Subject: FW: App Ref: AL/62/20/PL - Ormiston Six Village Academy- Sport England Ref: PA/20/SE/AR/56555

Subject: App Ref: AL/62/20/PL - Ormiston Six Village Academy- Sport England Ref: PA/20/SE/AR/56555

ORMISTON SIX VILLAGES ACADEMY

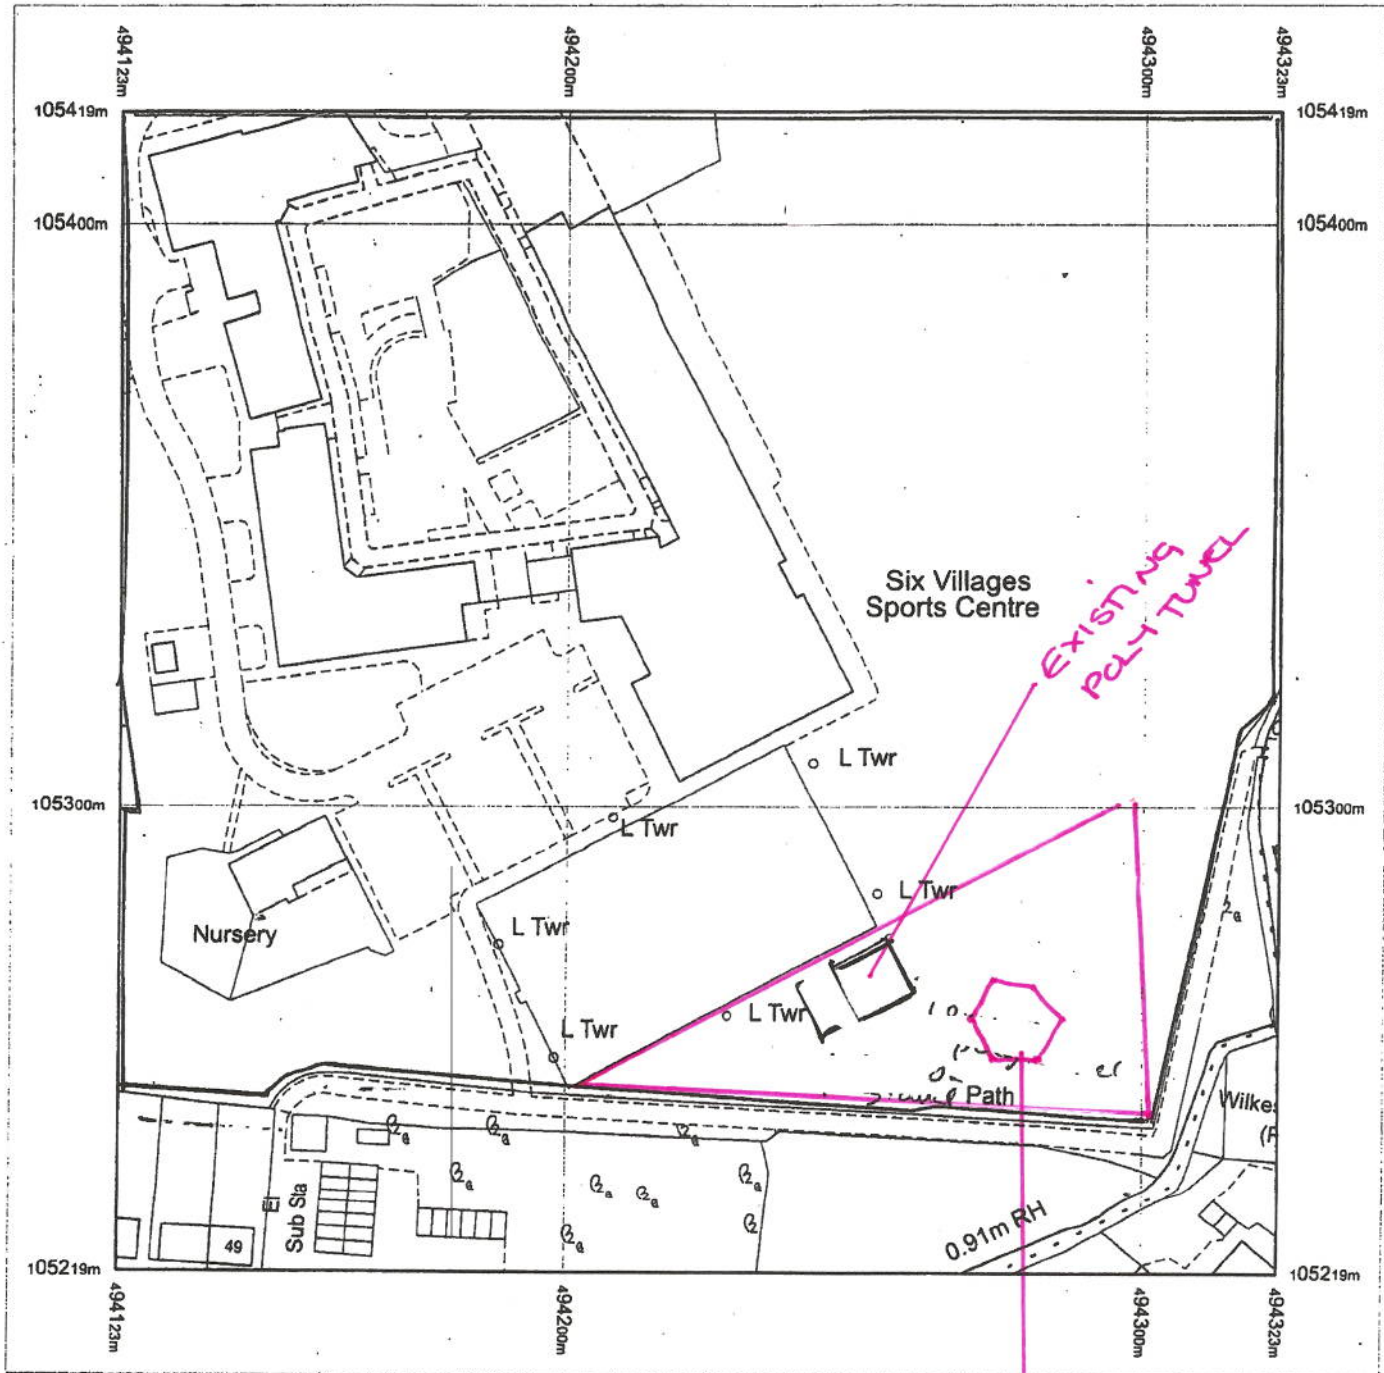
1. A plan showing the development's relationship with the existing playing pitches on this part of the site. The proposed timber lodge appears to be sited on part of the playing field that has been marked out for formal playing pitches in recent years. However it is not possible from the drawings and information submitted to identify what the impact of the structure would be on those playing pitches and whether, if they are affected, that the pitches together with adequate safety run off areas can be satisfactorily re-provided.
